# PRELIMINARY AND FINAL DRAINAGE PLAN AND REPORT

## FALCON STORAGE SUBDIVISION

PCD File No. PPR2232  
PCD File No. MS232

SUBJECT: Preliminary and Final Drainage Plan and Report  
Falcon Storage Subdivision

TEMPORARY SEDIMENTATION BASIN (TSB)

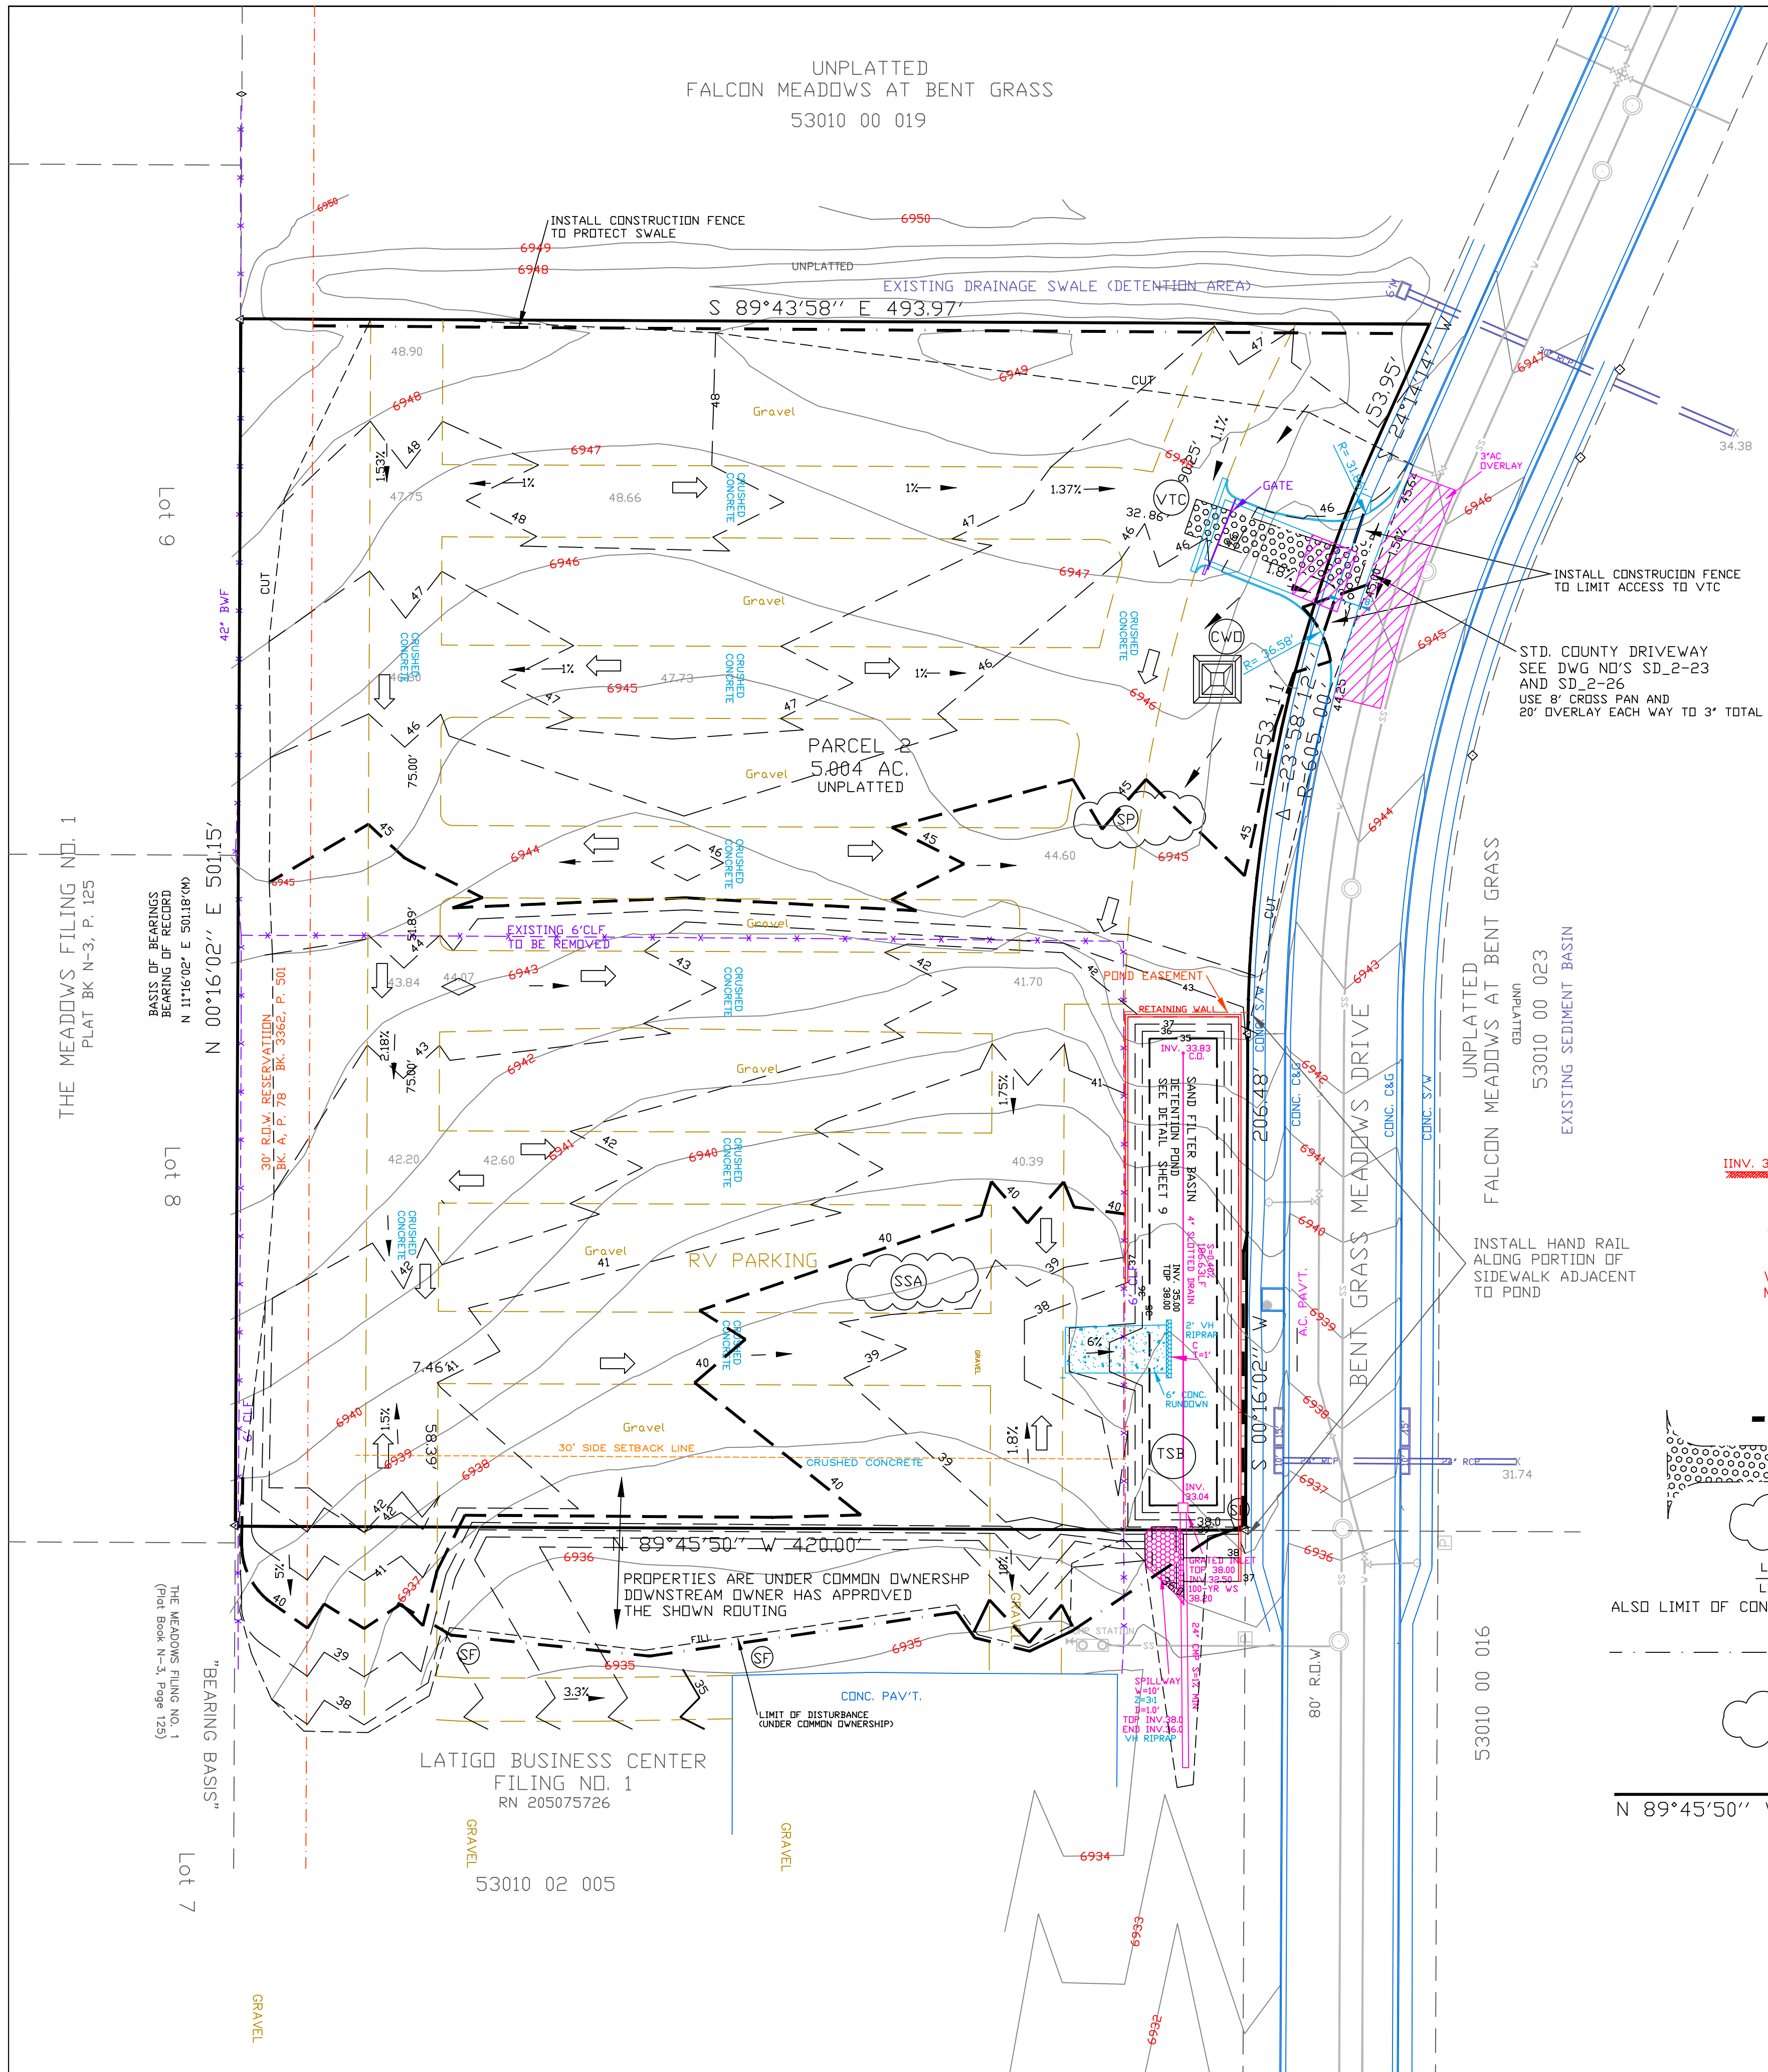
Assign a name/number to all PBMPs and then update all submitted text and drawings accordingly with consistent labeling throughout (example: "Pond A" or "Pond 1").  
Unresolved

please analyze and state whether the existing pond accounted for this sites developed flows. Address any improvements/upgrades needed to the pond. If the existing pond did not account for developed flows from this site provide detention onsite or identify the necessary upgrades needed for the existing pond and provide CD's of work to be done by this development.
